500 Coors Sw

DRAINAGE REPORT INFORMATION SHEET

PROJECT TITLE Warehouse Bldg

RE: GRADING AND DRAINAGE PLAN FOR 500 COORS
BLVD. S.W. DATED AUGUST 17, 1981

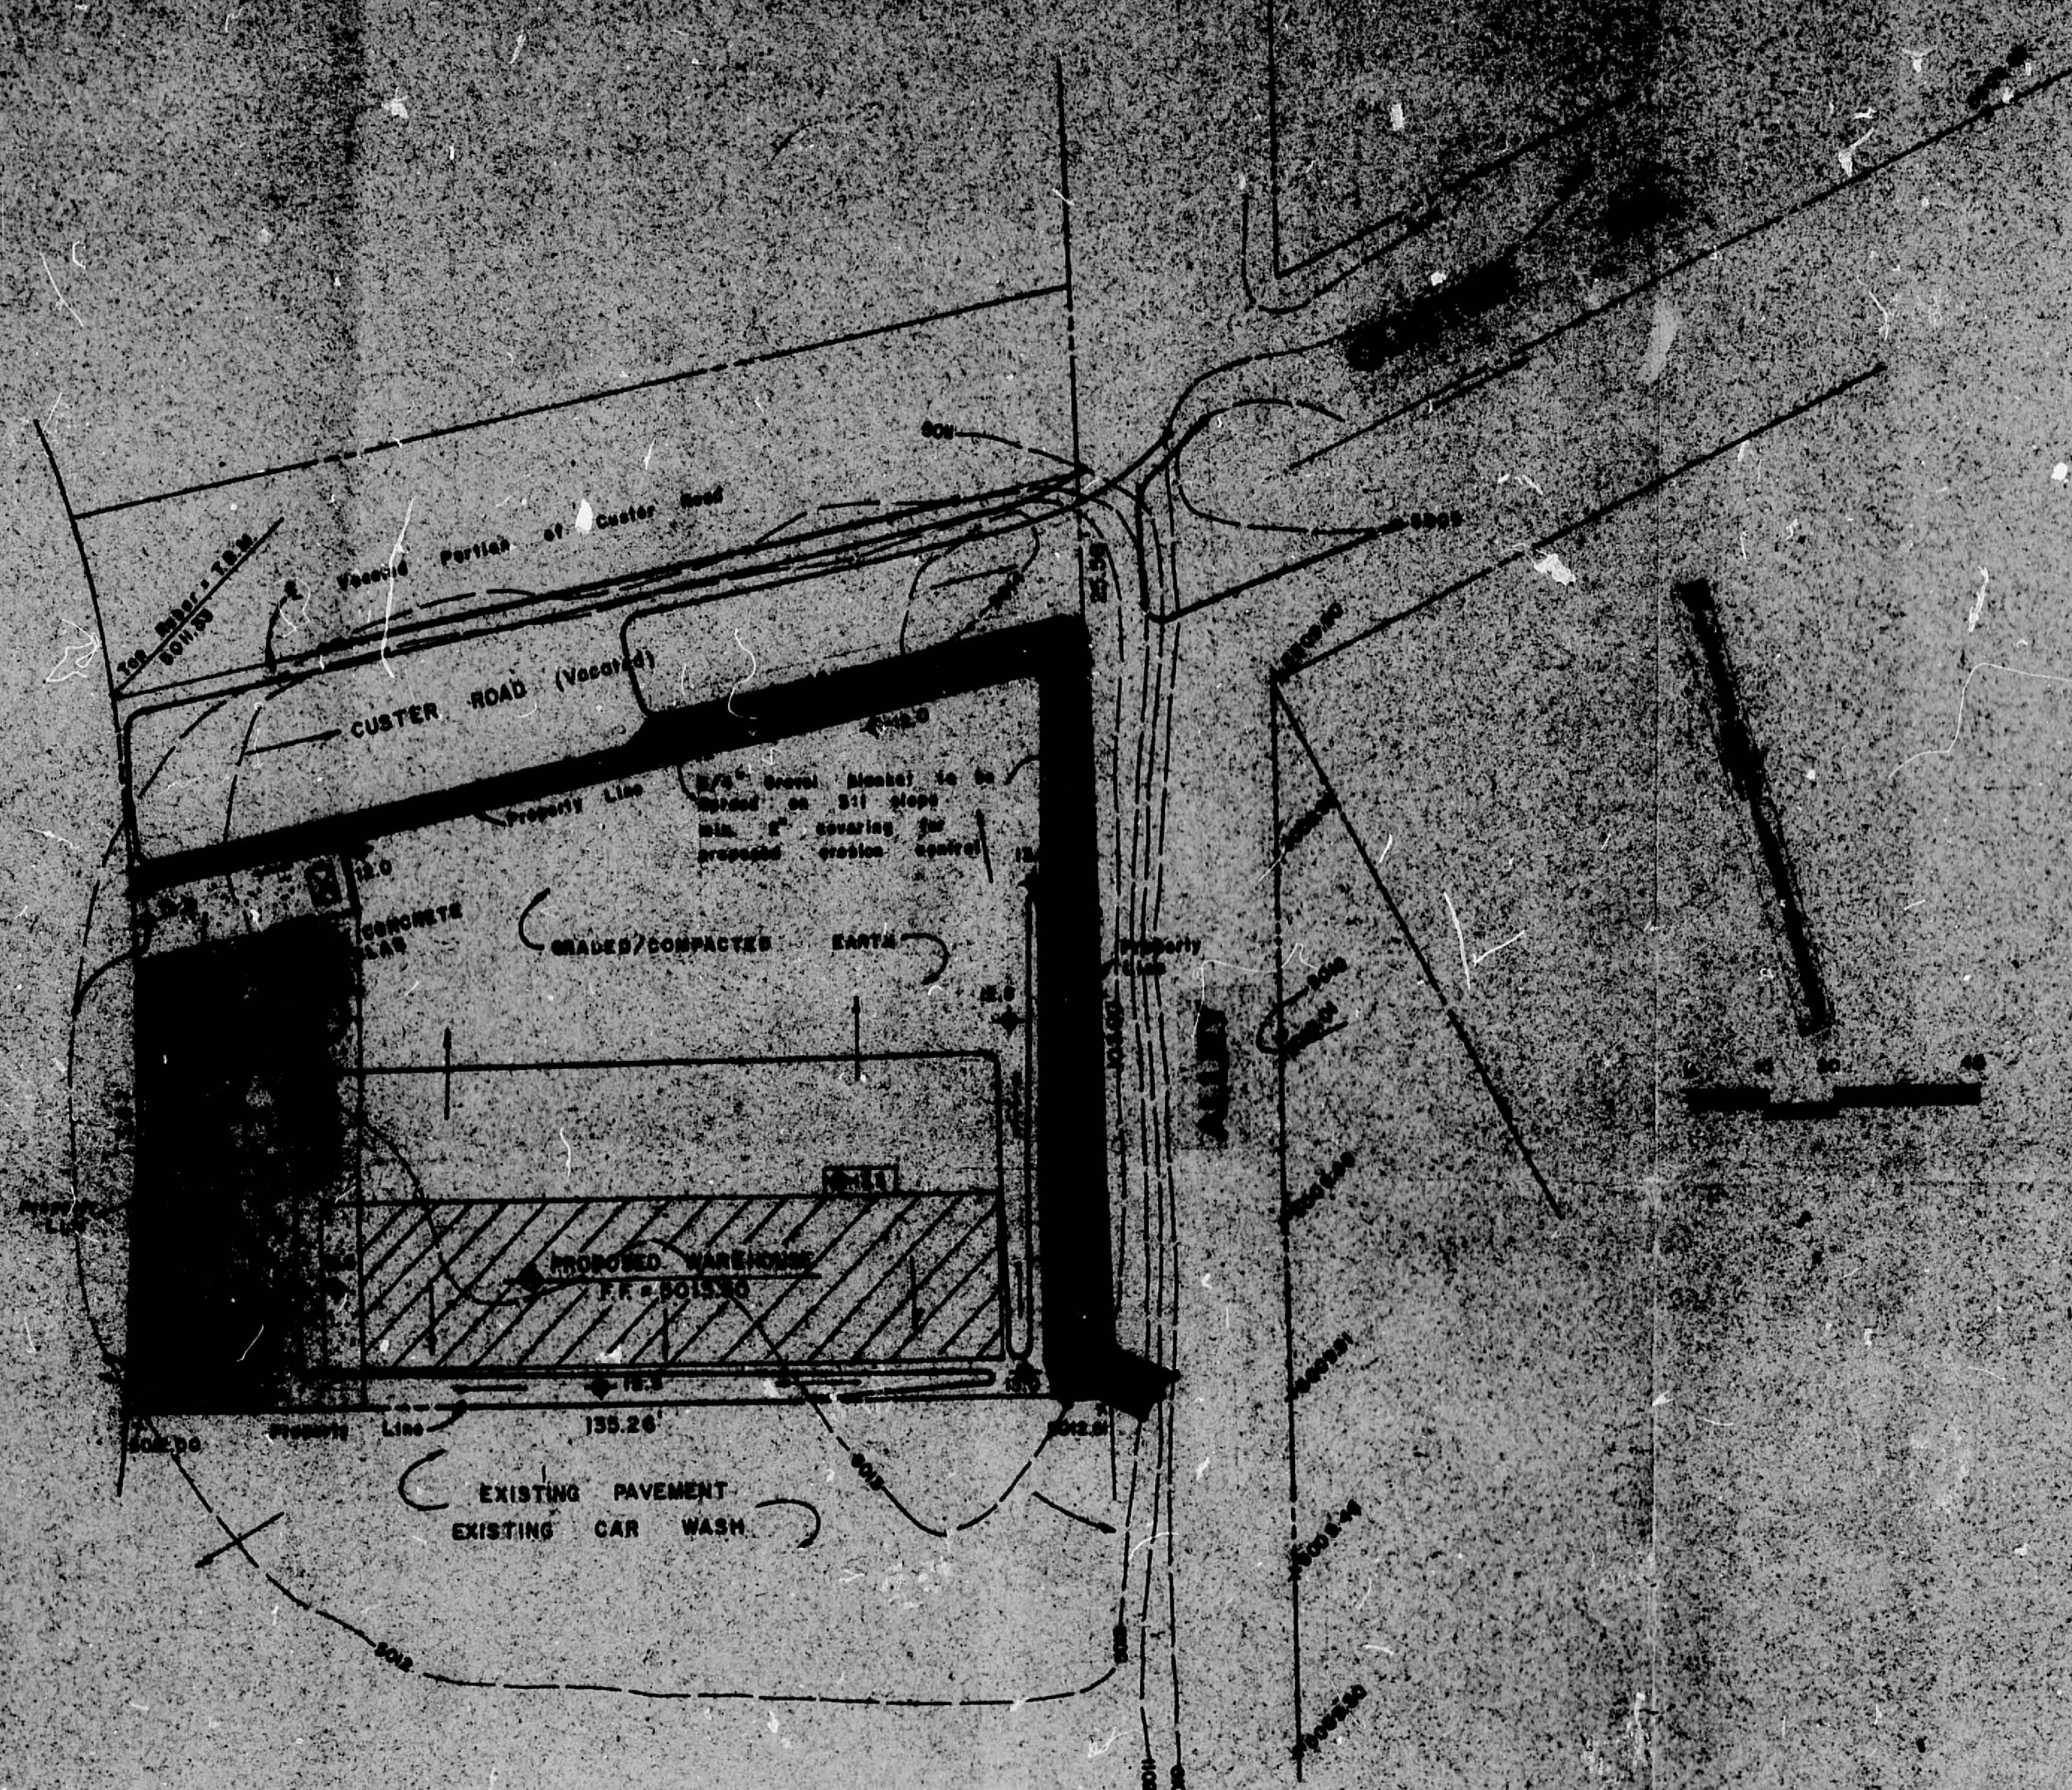
- ① show complete lot on plot plan
- ② define asphalt, concrete, grassed, or landscaped areas.
- ③ need proposed alley grades, including a copy of the profile, available @ City Design office
- ④ show curbs & sidewalks & show that all drainage exits properly through city approved curb cut.
- ⑤ discuss offsite flows
- ⑥ any local conditions affecting drainage
- ⑦ professional stamp is required.

- ① Again, proposed alley grades required.
- ② On the south side of the warehouse show the required grades to construct the proposed swale.
- ③ Show benchmark
- ④ Since your grading plan indicates drainage to an unimproved alley, we will need the existing alley grades to determine the alley's outfall point.

1. Erosion Control Plan for the proposed swale along the north property line and the proposed 2:1 slope along the east property line.
2. Notes defining property line, asphalt and planting area.
3. Storm runoff cannot be discharged onto the adjacent property owner to the south without his consent. Also, recommend the elimination of any unnecessary discharge into the unpaved alley.
4. Legend indicating symbols and abbreviations used.
5. Professional engineer's or surveyor's stamp indicating who performed the survey.
